Subject: RE: Planning Consultation on: FP/51/21/PL

Demolition & erection of 1 No. dwelling with associated works. This site is in CIL Zone 4 & is CIL Liable as new dwelling. (FP/51/21/PL)

**32 Sea Drive,
Felpham,
PO22 7NE**

Rear (South) Elevation
Scale 1:50 @ A1

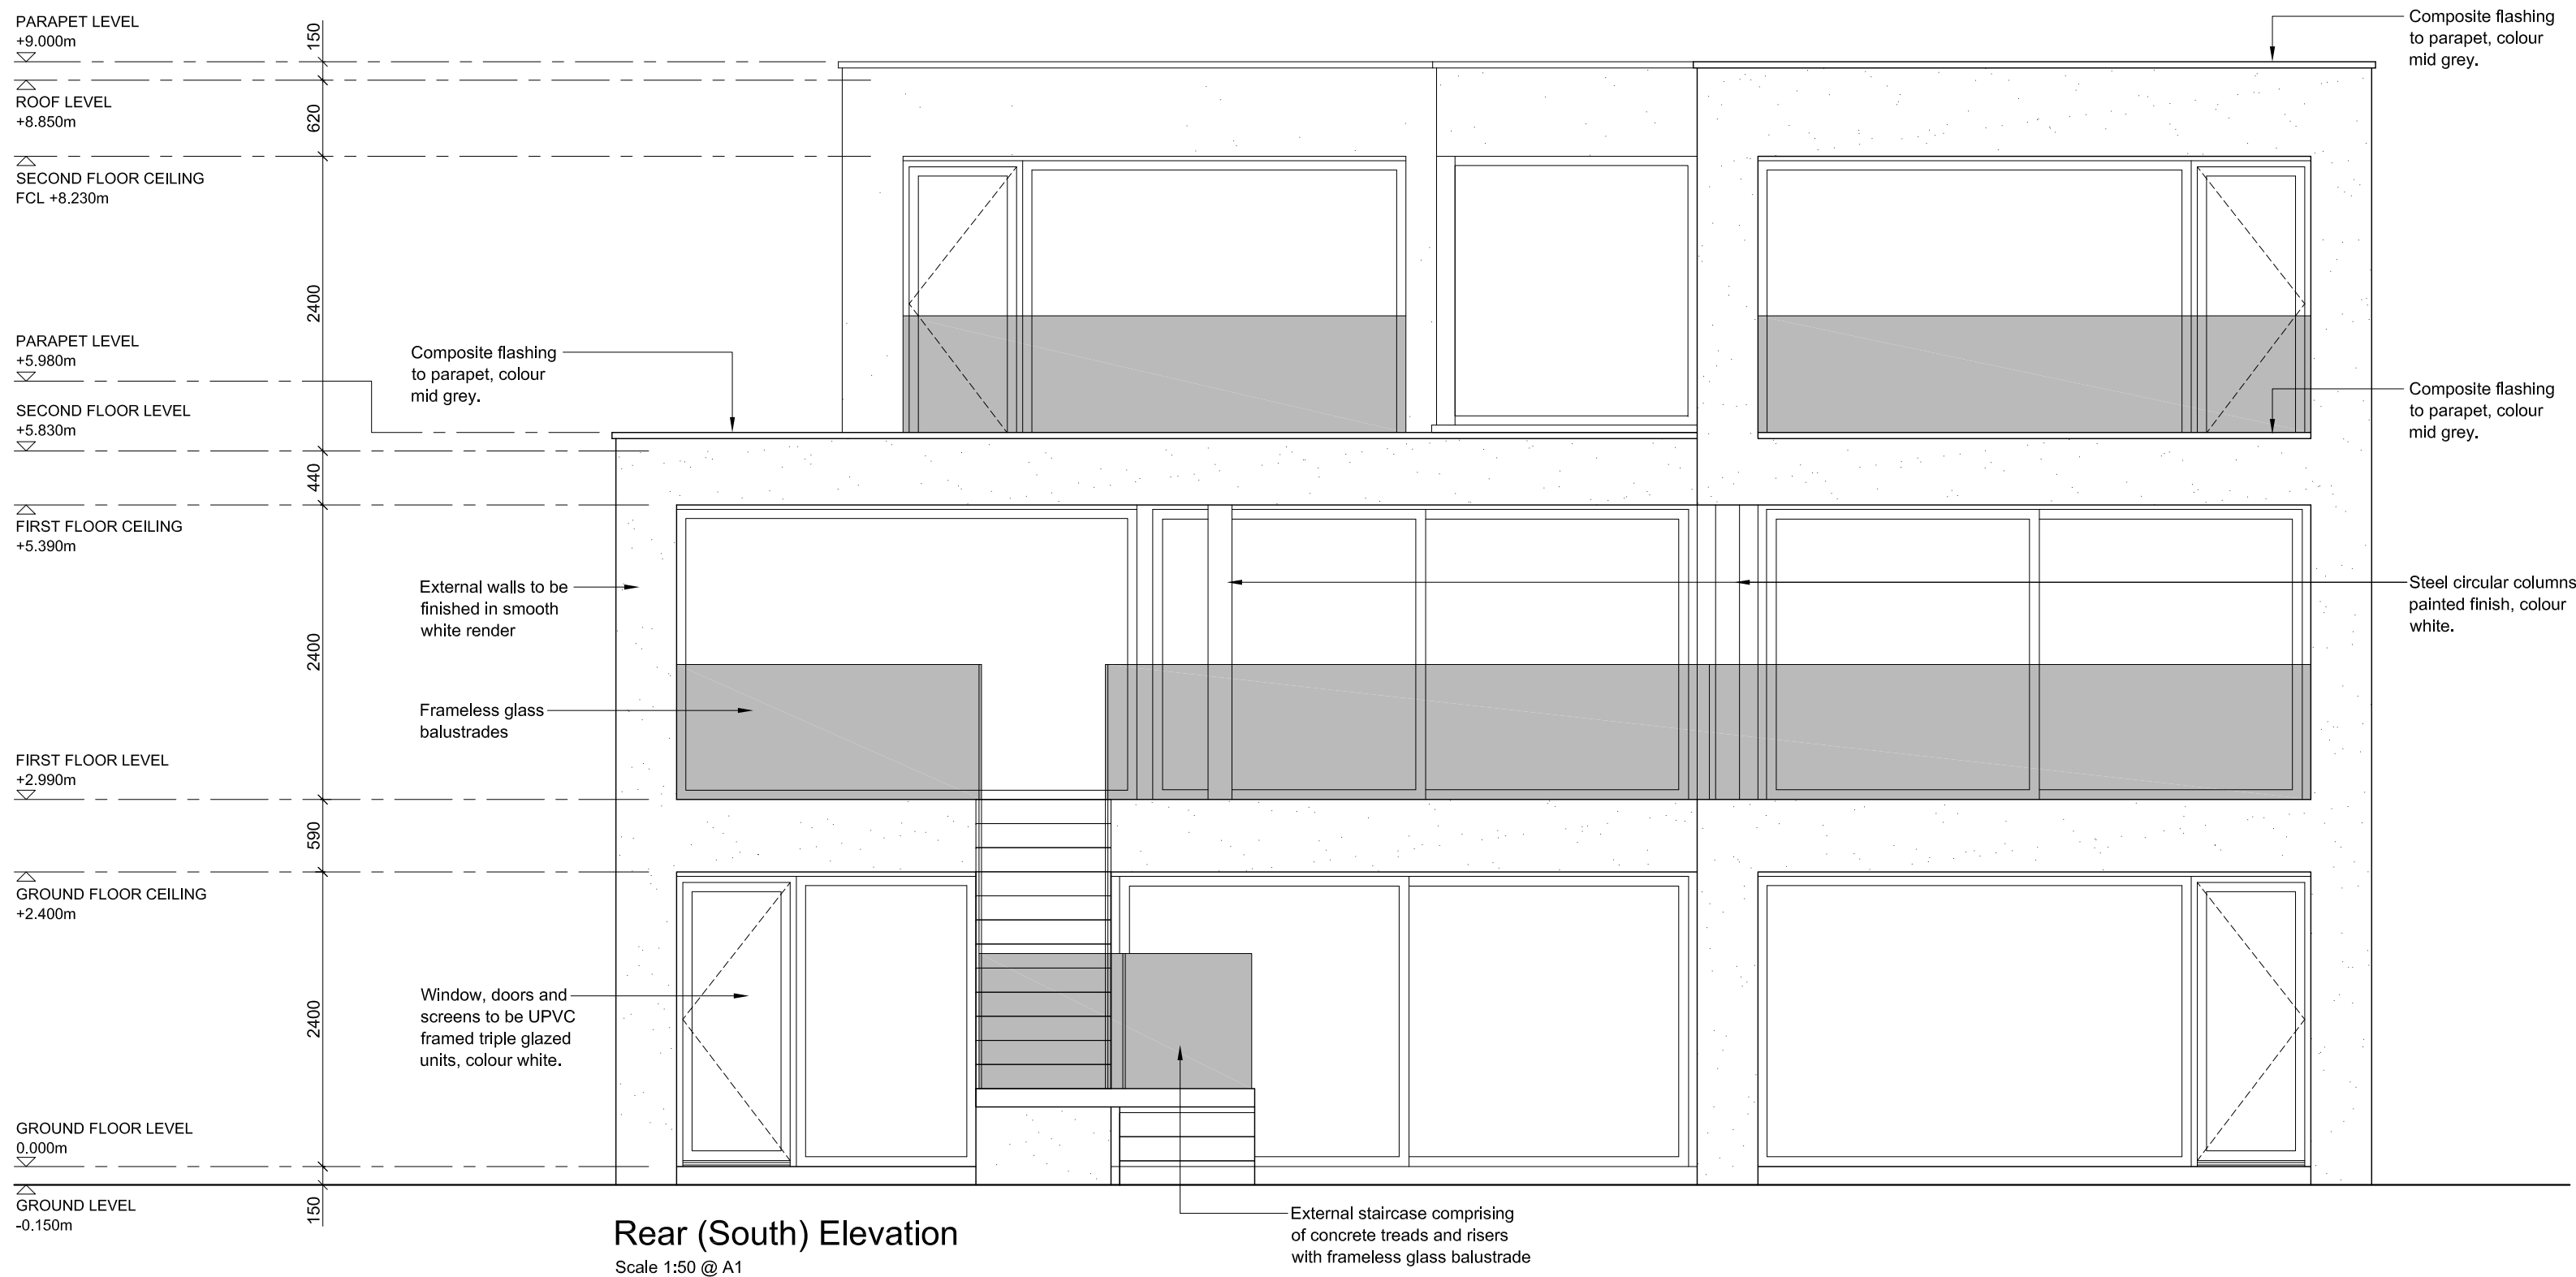
The ground levels in the garden are relatively low and looking at the drawing of the southern elevation it would appear that the floor levels are almost flush with the ground. It would be prudent to consider raising the floor levels slightly to prevent water ingress and improve the property's flood resilience.
